Application No: CM/52/21/DOC
Site Address: Bairds Farm Shop, Garden Centre Crookthorn Lane Climping BN17 5SN
Description of works: Approval of details reserved by condition imposed under ref CM/16/21/PL relating to Condition Nos 6 - grease trap/seperator, 7 - extraction of cooking odours and 8 - boundary treatments to southern & western boundary.

Thank you for your internet representation made on 23rd September 2021 which has been recorded as an objection with the comments as follows:

N DISTRICT COUNCIL CM/52/21/DOC

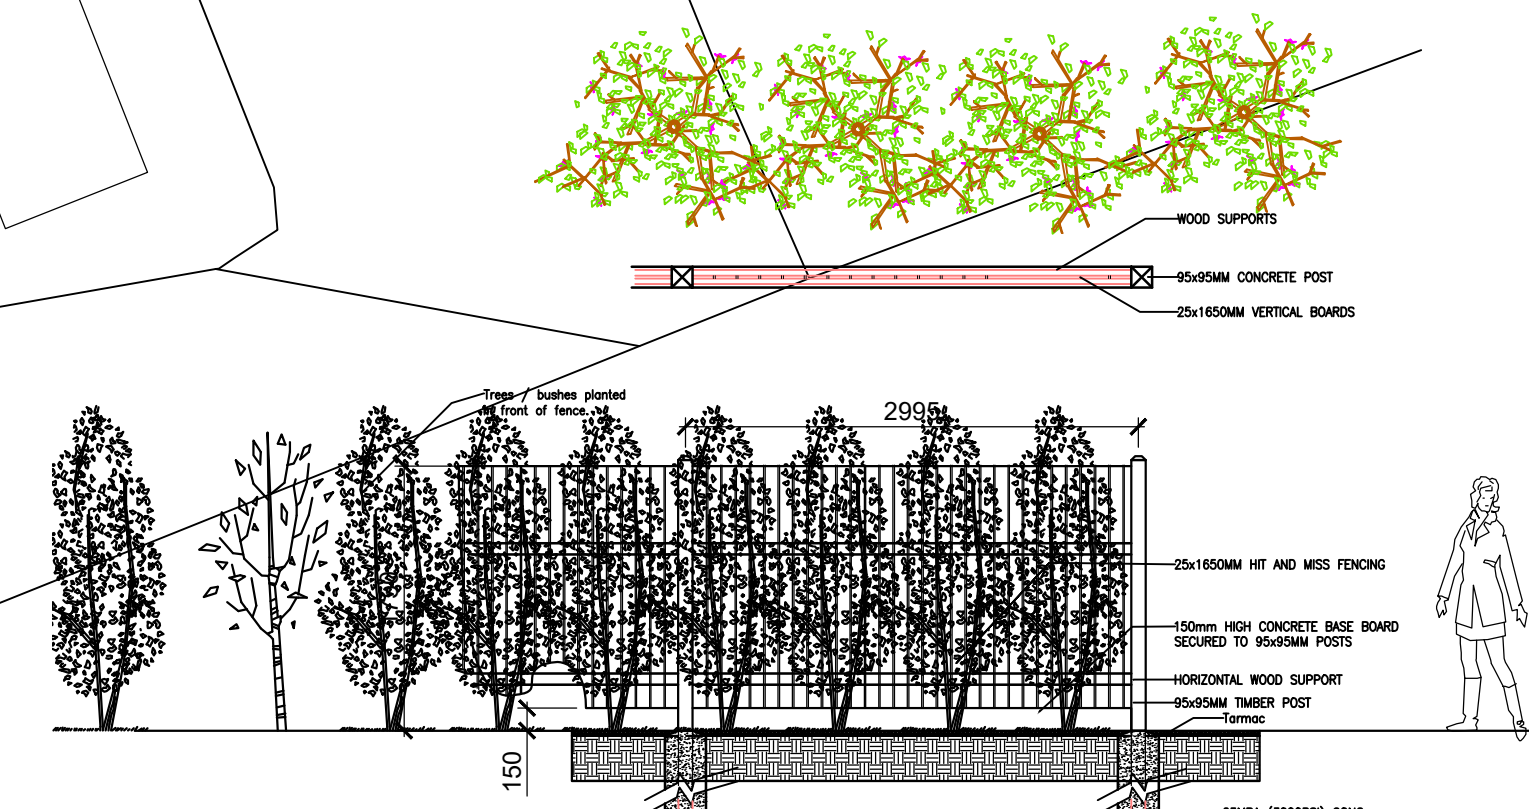
Please would you help ensure that the listed building 'The Cottage', which is within 18m of this unsightly shipping container, is protected from the odours and cooking smells or a fast food cafe, and pollution from cars queuing for the drive-thru, and is protected from noise via the boundary treatments.
